Subject: FW: Planning Consultation on: Y/15/21/DOC Land North of Yapton Primary School

From: Laura Gibbons <Laura.Gibbons@arun.gov.uk>
Sent: 09 March 2021 11:58
To: Planning.Responses <Planning.Responses@arun.gov.uk>
Cc: Simon Davis <Simon.Davis@arun.gov.uk>
Subject: RE: Planning Consultation on: Y/15/21/DOC

Condition 9- surface water drainage strategy

RAINWATER PIPE CONNECTION

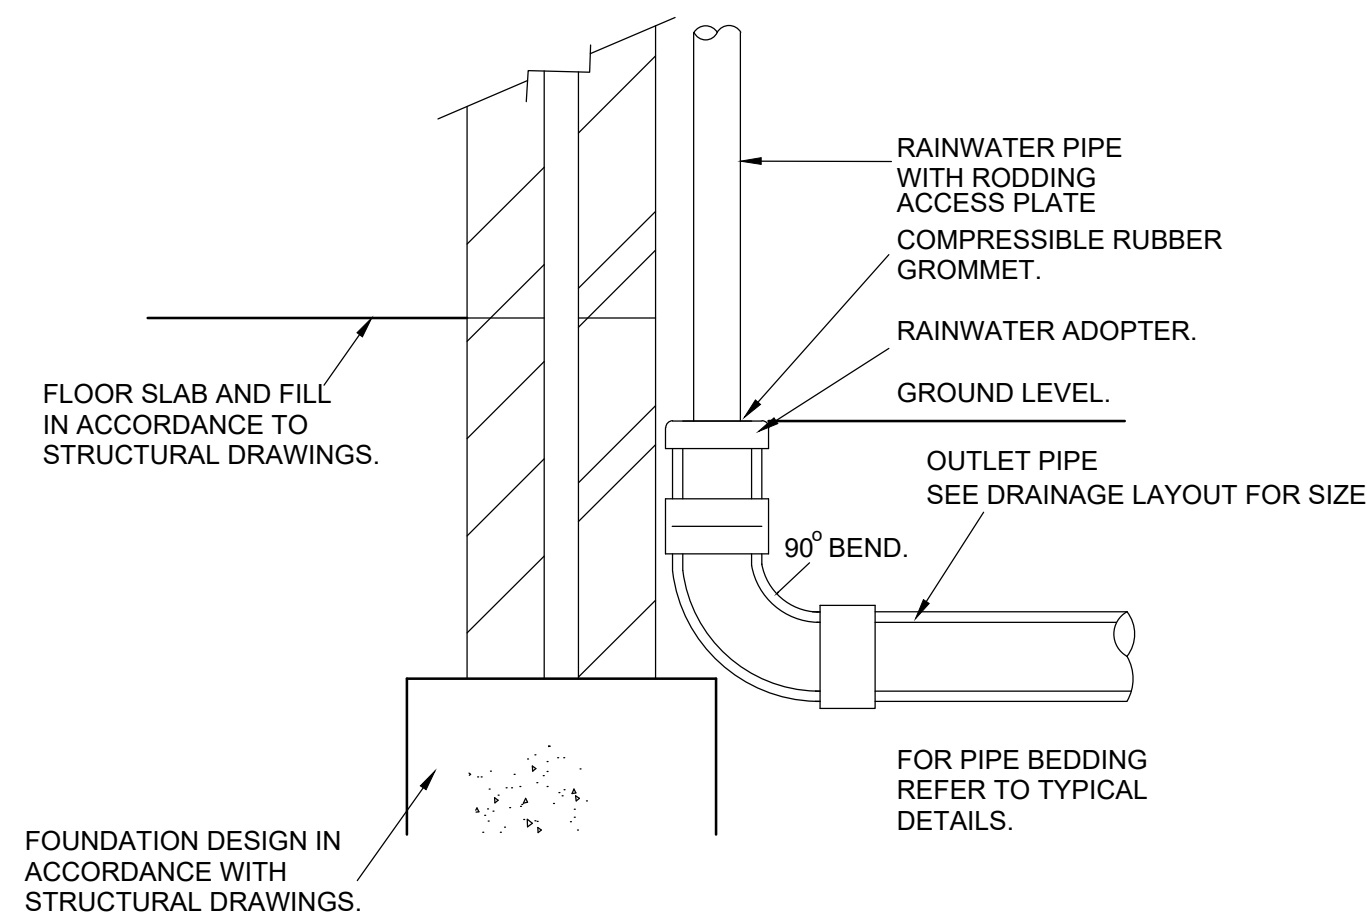
6. Please specify sand bedding and surround to infiltration blankets. Bedding layer specification provided on drawing YAP-180-031C2. *Okay, point closed.*

7. Please identify on construction details of infiltration blankets that invert level is to be as per drainage layout drawings. Currently you are showing incoming pipes at the base of crates. Infiltration blanket detail adjusted as requested. Please see drawing YAP-180-031C2. *Okay, point closed.*

8. Please remove irrelevant construction detail drawings, e.g. hybrid infiltration blankets, infiltration blankets with overlying infiltration basins, and gully grating within infiltration basin. Construction detail drawing updated - please see drawing YAP-180-031C2. *Okay, point closed.*

13. Please provide a construction detail which shows connections into permavoid crates. Construction detail drawing updated - please see drawing YAP-180-031C2. *Okay, point closed.*

Job Title			
LAND AT STAKERS FARM, YAPTON			
Drawing Title			
HIGHWAY CONSTRUCTION DETAILS (SHEET 1 OF 2)			
Client			
DANDARA LIMITED (SOUTHERN)			
Scale	Date	Designed	
AS SHOWN @A1	SEP 2020	AK	
Drawn	Checked	Approved	
JK	AK	SW	
Job No	Drawing No	Rev	
19-156	YAP-180-035	T4

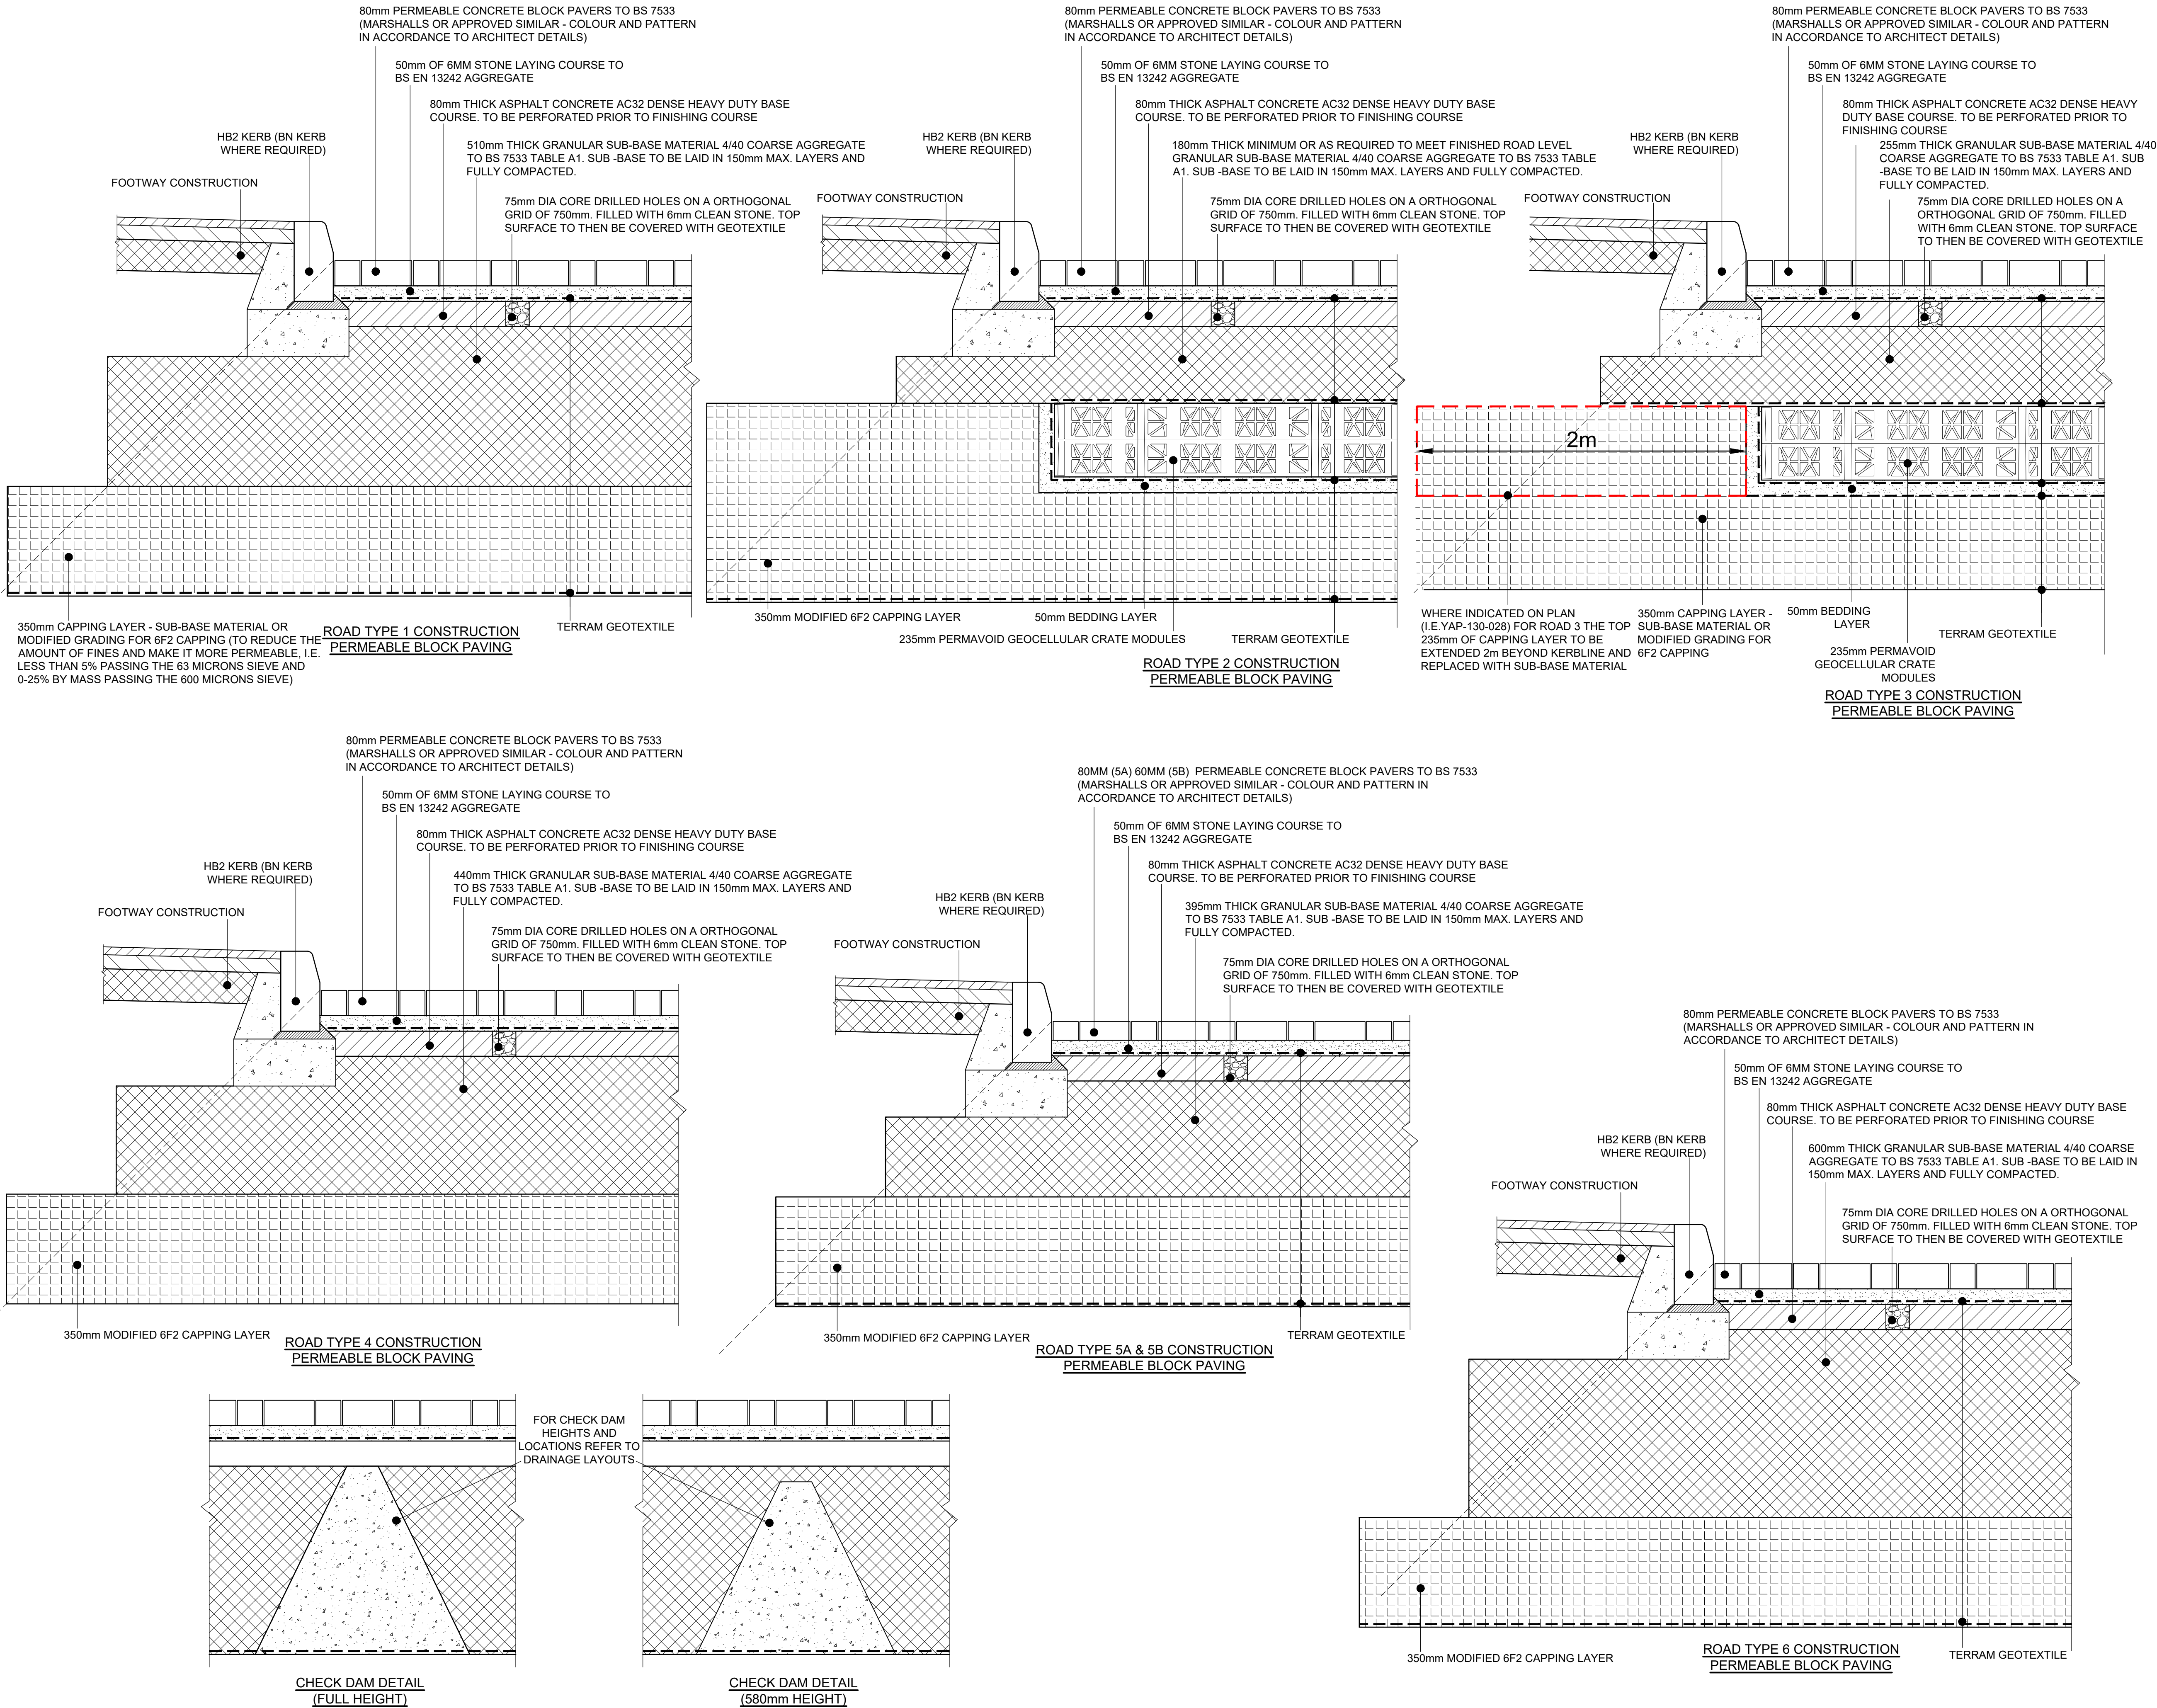
9. The construction detail drawings for the permeable paving and highways show a capping layer below the sub-base. The capping layer specified is not appropriate as it contains a high degree of fines and will not be permeable. Please remove this capping layer or replace it with a suitable permeable material. Capping layer specification adjusted to match sub-base – please see drawing YAP-180-035C2. *Okay, point closed.*

10. Please specify the material for the bedding layer underneath and around the permavoid crates on the permeable paving construction details. Construction detail drawing updated - please see drawing YAP-180-035C2. *Okay, point closed.*

Drawing Title
DRAINAGE LAYOUT - PLOTS 24-32
38 UNIT SITE - SHEET 2 OF 6

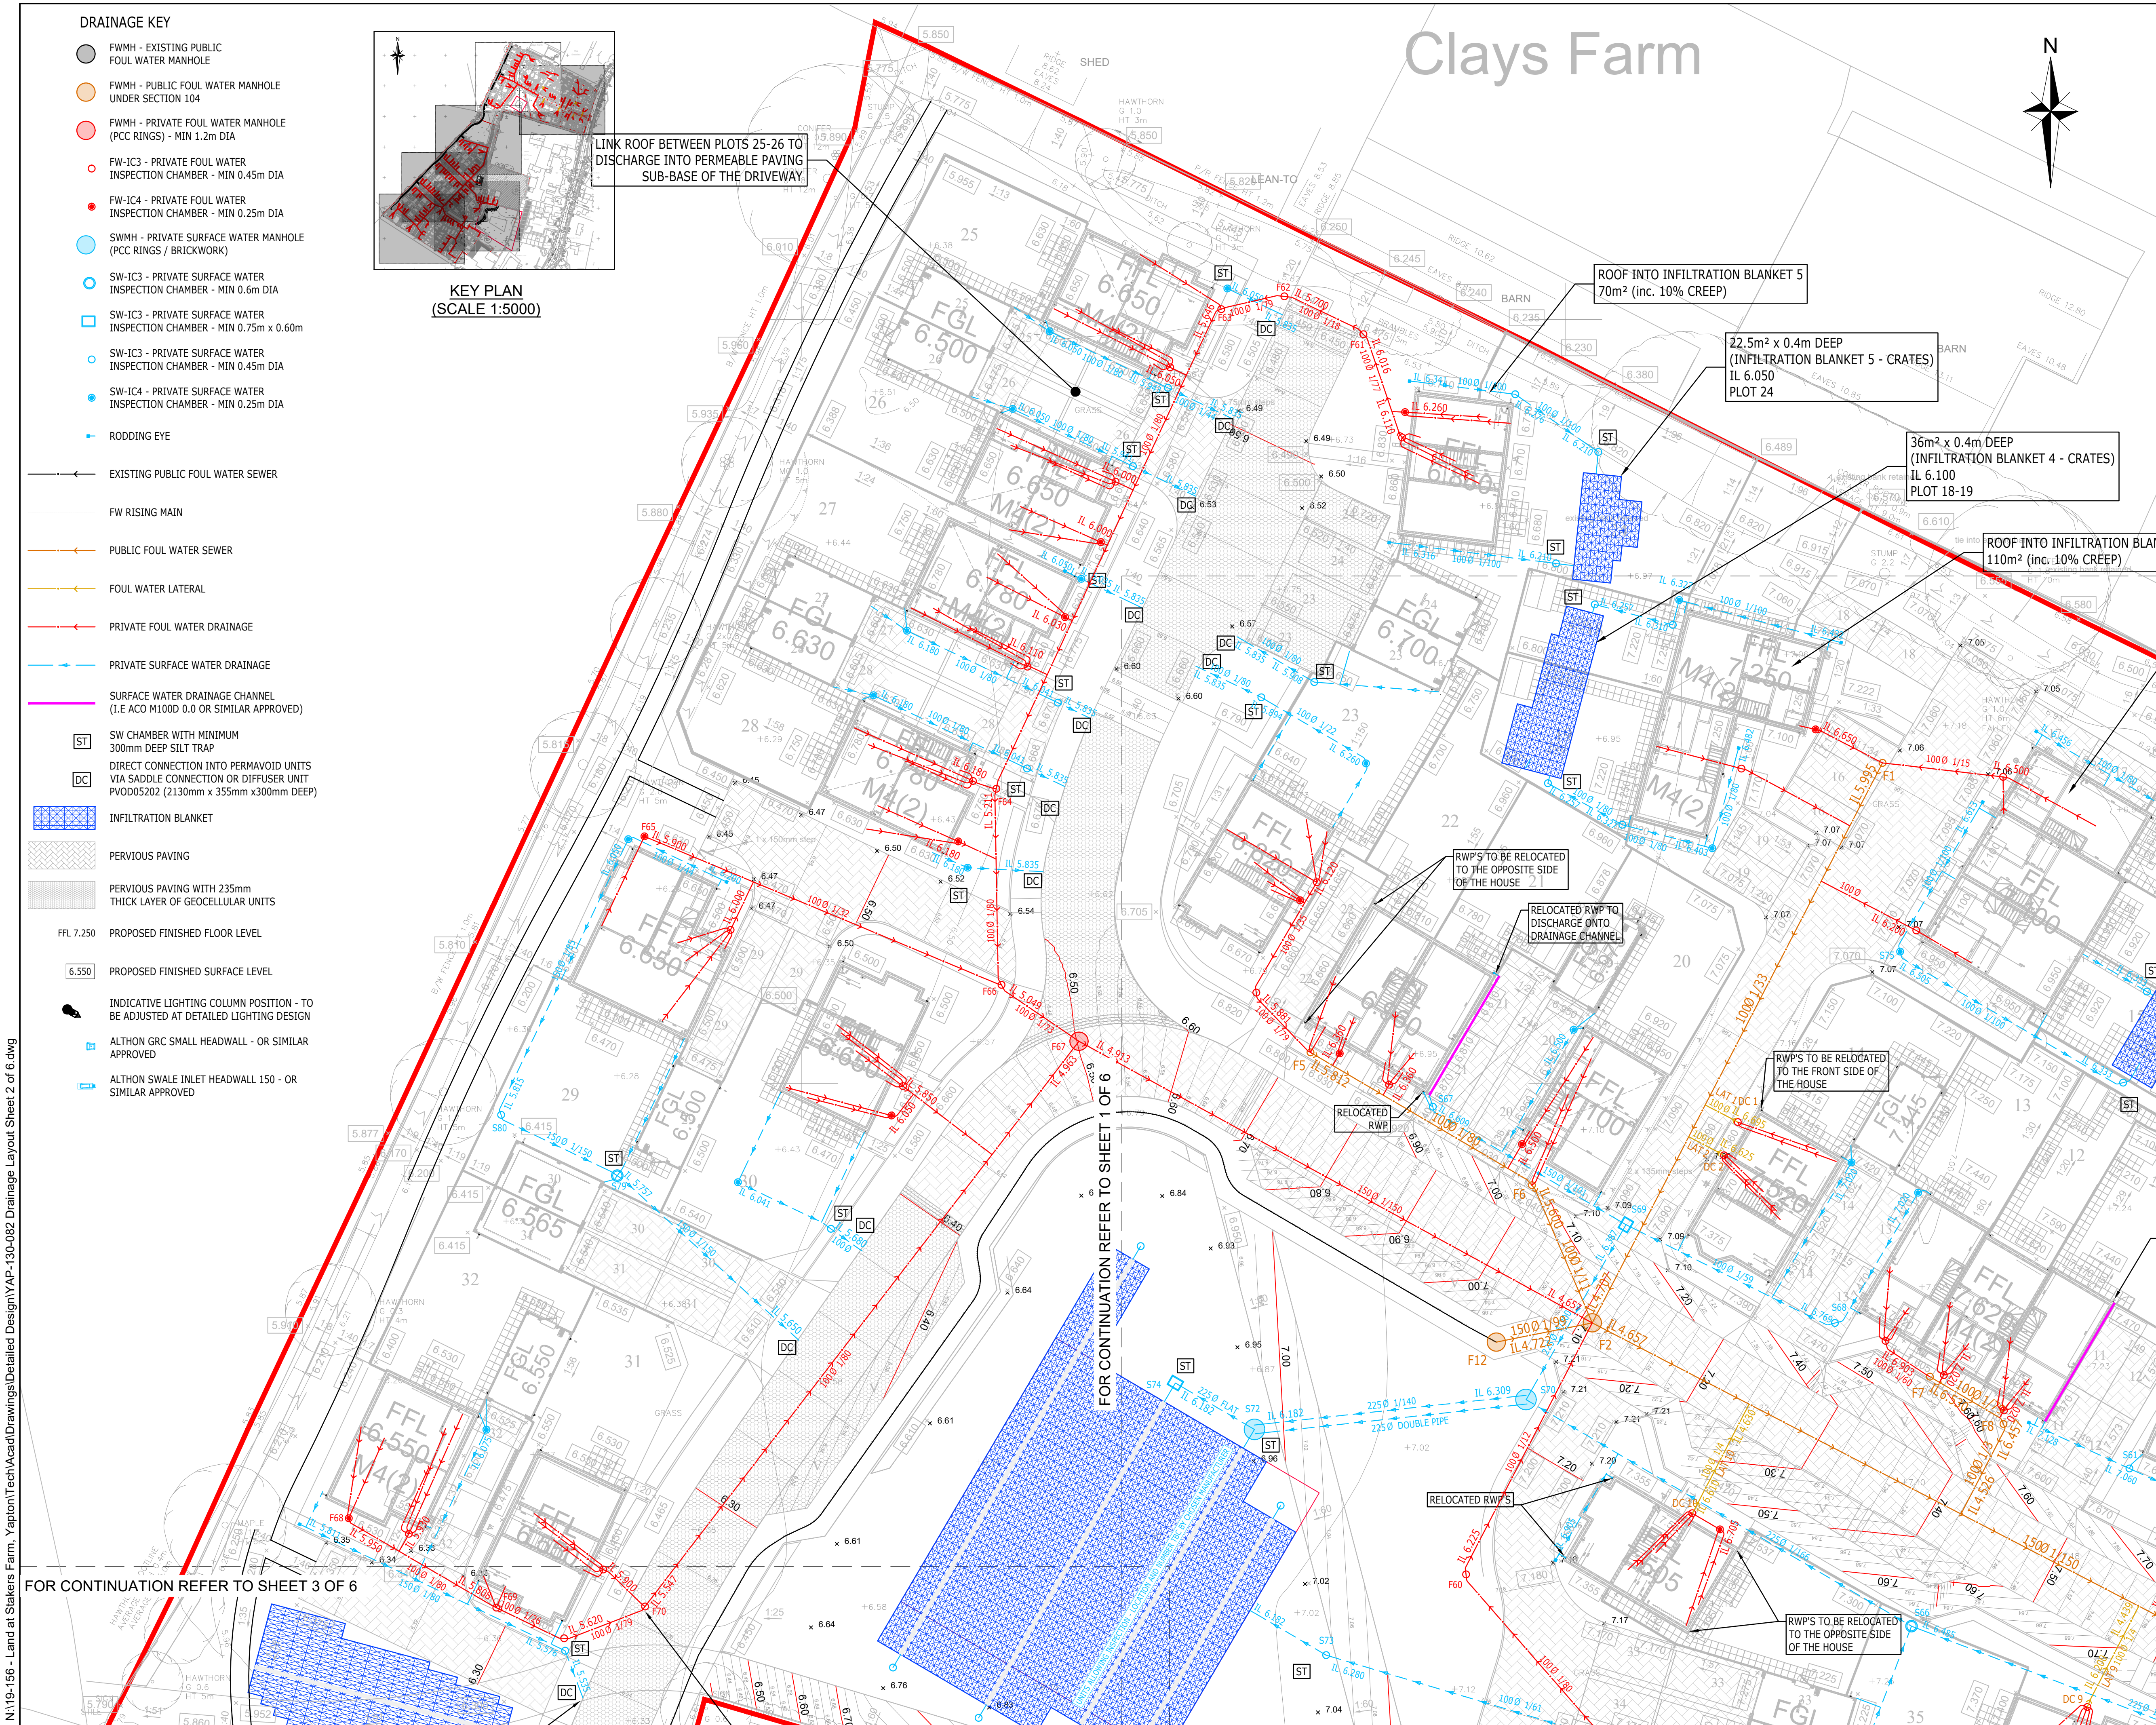
11. Road type 2 which drains plots 23, 25-27 appears to have incoming invert levels at the base of the structure, rather than above the 1 in 10 year plus cc water level. Please revise. Drainage design updated. Please see drawings YAP-130-082C2 and YAP-180-031C2. The actual connection into the Permavoid must be constructed at the base due to the proprietary saddle connection fitting part, however the surface water (SW) system is designed so the last SW chamber (silt trap) is above the 1 in 10 years plus cc water level within permeable paving system, i.e. SW system is not lower than 5.995m AOD, which is a water depth of 0.16m (please see Road 2 with plots 23,25-28_1 in 10 yrs with CC_Rev_B calculations) for the storm design event added to the permeable paving base level of 5.835m AOD.

The same will apply to Road 3, where final connection into Permavoid must be constructed at the base due to the proprietary saddle connection fitting part. In this instance the water depth for the 1 in 10 yrs plus cc event is 0.288m (please see Road 3 plus plots 29-32_1 in 10 yrs with CC_Rev_C calculations) and with permeable paving sub-base level of 5.430m AOD (measured at the downstream end of Road 3, please see drawing YAP-130-028C1) results in the design water level of 5.718m AOD. We have designed last SW chamber (silt trap) prior to Permavoid connection to be not lower than this level and downstream pipe do not have any additional connection thus serves as connection conduit only with the actual SW system not being subjected to surcharge during the 1 in 10 yrs plus cc event. *Unclear on where any alterations to design have been made, incoming invert levels and formation levels appear the same.*

12. Road type 2 which drains plots 23, 25-27 appears to have an insufficient total depth in areas. Formation level appears to be flat at 5.835m, with a total minimum construction depth of 625mm (according to your construction detail drawings) gives a minimum finish level of 6.46m. Yet you have areas which are proposed to have a finish level of 6.45m. Please review all permeable paving areas to ensure that minimum construction depths can be achieved. Levels reviewed with minimum construction depths achieved. Please see YAP-130-081C2, YAP-130-082C2 and YAP-130-028C1. *Okay, point closed.*

16. Cover levels of MH1 (S61), MH3 (S63), MH5 (S65) MH8 (S68), MH 9 (S69) are inconsistent between calculations and layouts. Please correct to ensure consistency.

17. Please clearly show catchpits upstream of all connections into infiltration devices. SWMHs which are catchpits should be clearly identified on both layout plans and manhole schedules.
